Site: 4719 86th Ave SE SP
Mercer Island, WA 98040
TPN: 7598100420
Area: 28,644 sq ft. = .66 acres

Re: RFI dated February 2023 all corrections highlighted in yellow

City Arborist

TREE RETENTION CALCULATION

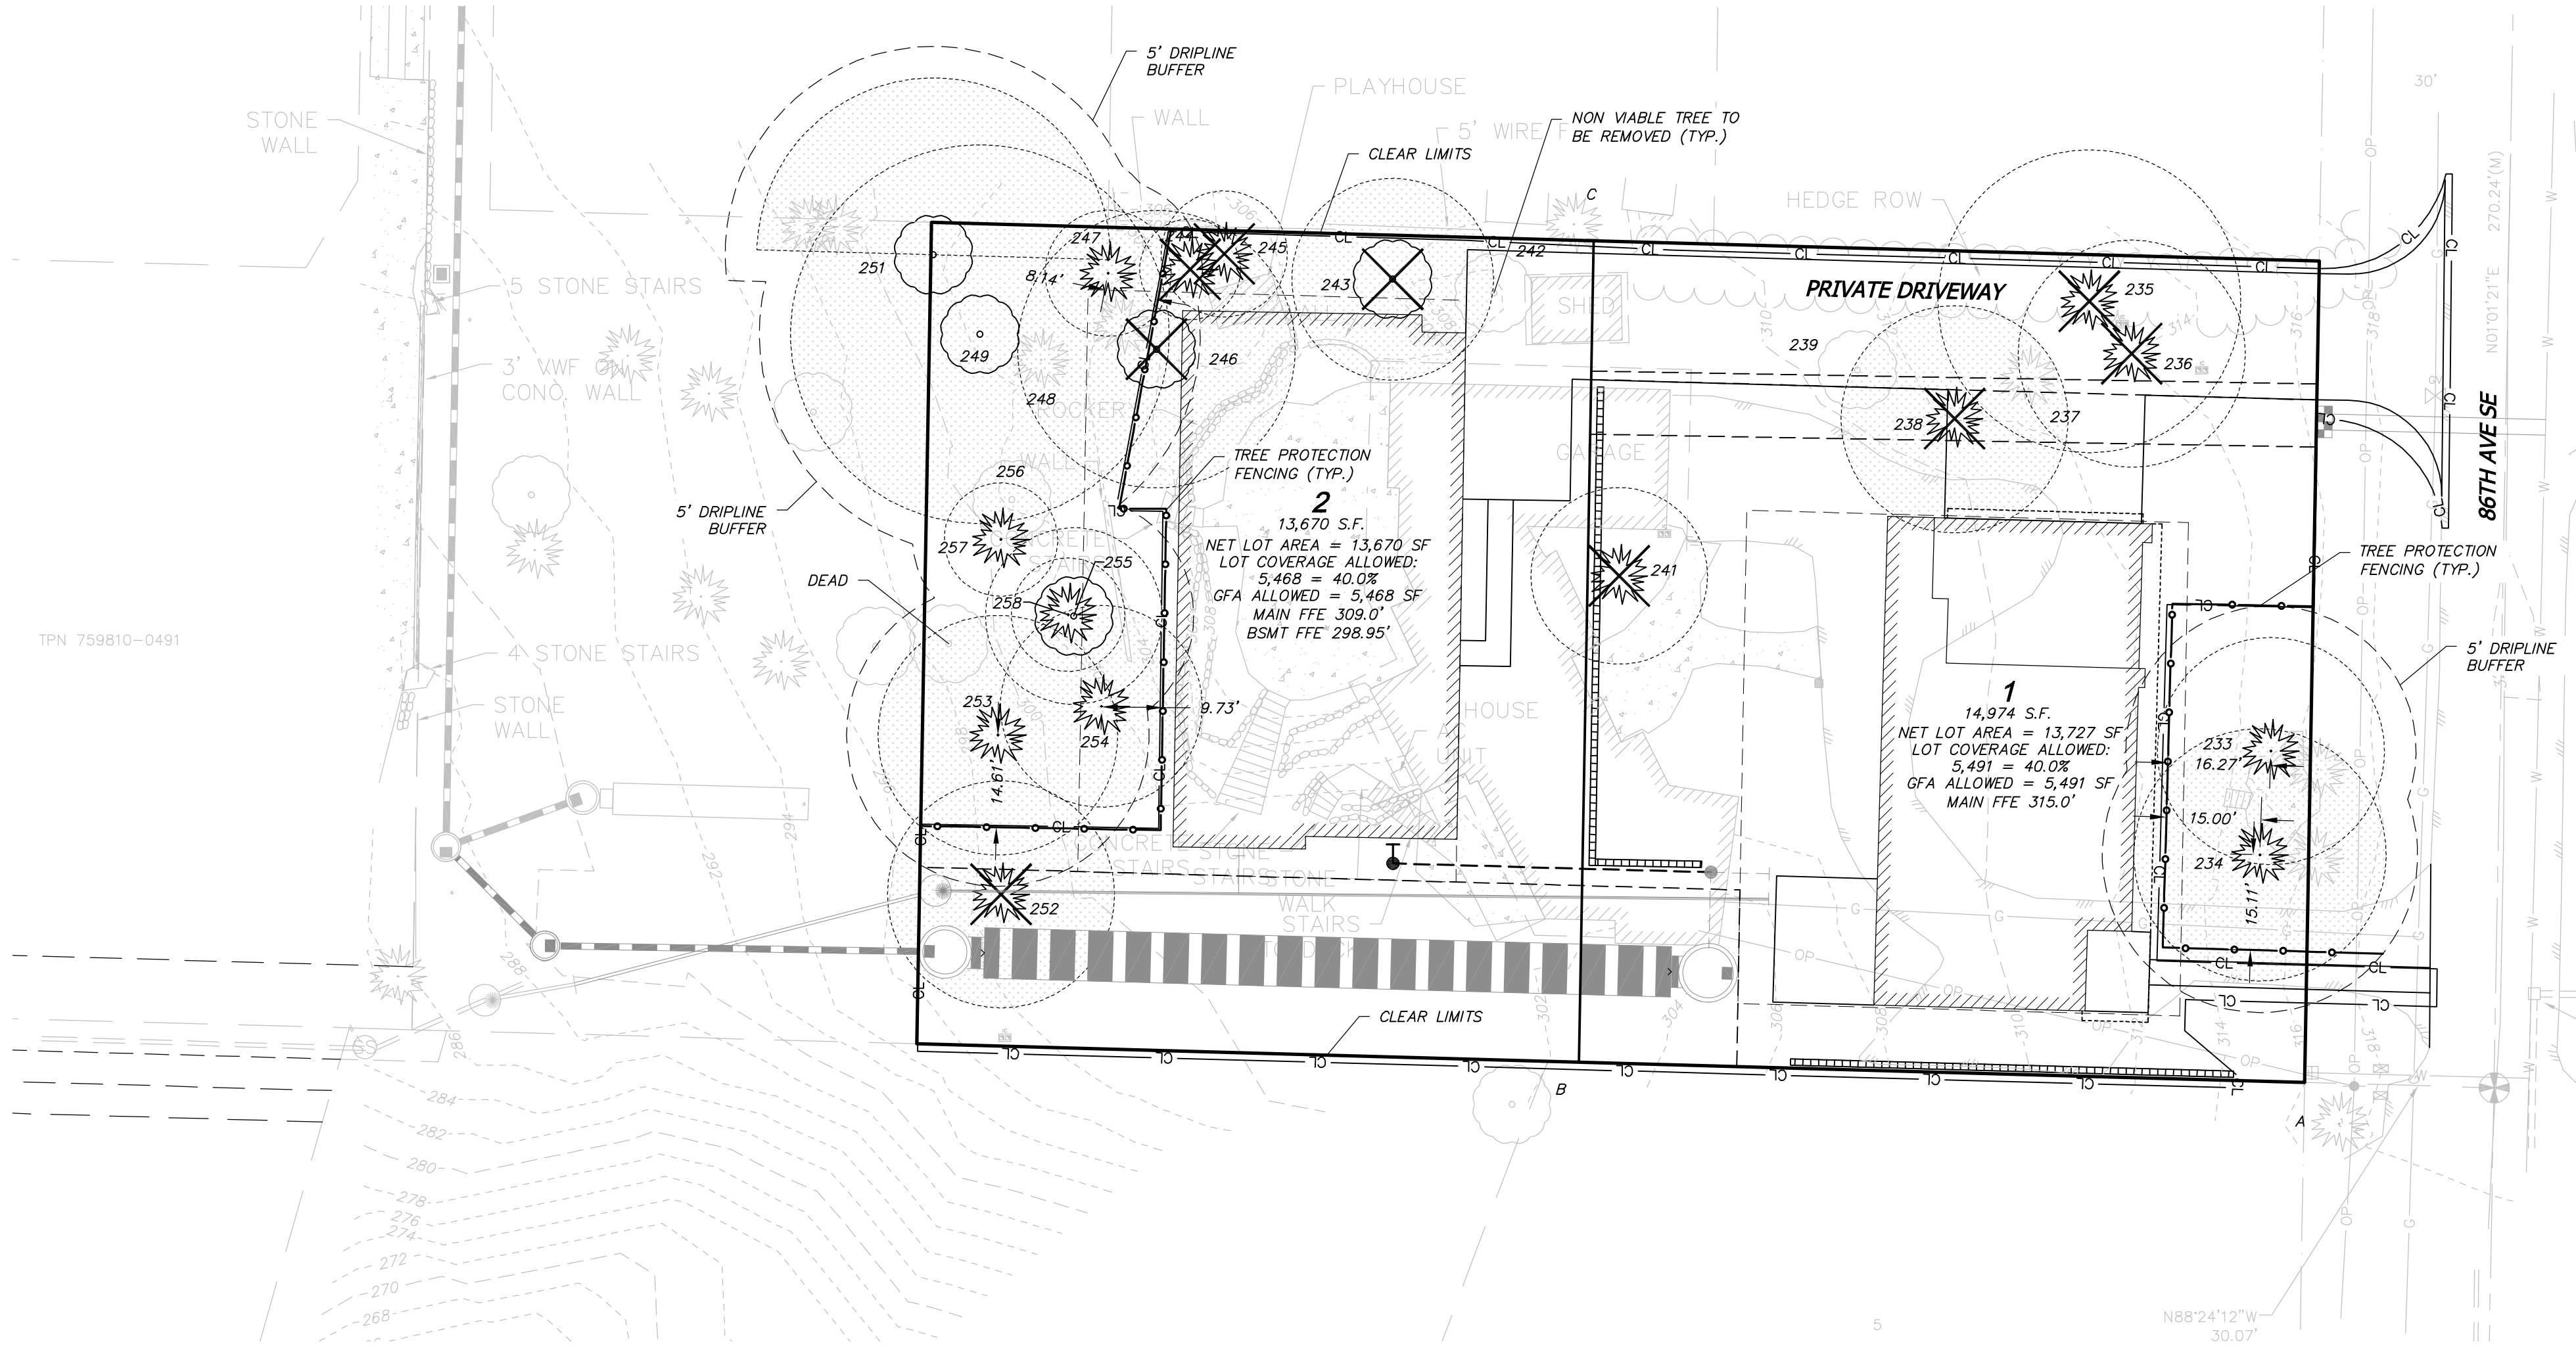
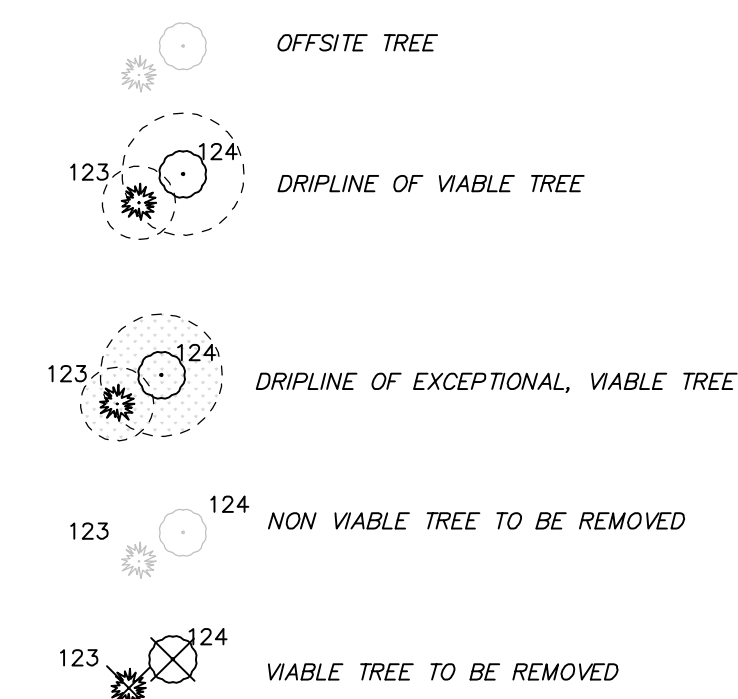
8. Please move the building pad and over excavation outside of the critical root zones of trees 233, 234, 249, and 253. Air excavation root analysis will need to be provided prior to construction to demonstrate that these trees will not be damaged by the proposed work. The analysis will need to call out the specifics of the project design. Alternatively, these trees could be proposed to be removed if the minimum required number of regulated trees will be retained. The building envelope was moved 5' to the west to reduce the potential impact of construction on tree #233 & 234) I have reduced the LOD by a 2' and 5' respectively (see "Onsite Tree Observation Table on pages 7-11). The soil around the roots will be air-evacuated and the exposed roots will be cut cleanly to BMP, ANSI 300 and ISA standards.

9. Please provide a tree replacement plan for at least 49 trees. If you can show that there is not enough space on the lot for the required replacement trees, you may request a fee in lieu that charges \$919 for each tree that cannot be replaced. A bond or assignment of funds will be required at the final plat, which will be completed before building permits for the lots are finalized.

Mitigation was originally 49 trees; however, the applicant has revised the site grading and retained additional trees. Mitigation is now thirty-six (36) trees. The site will only accommodate fifteen replacement trees requiring a fee-in-lieu-of of (21 trees X \$919) \$19,299.
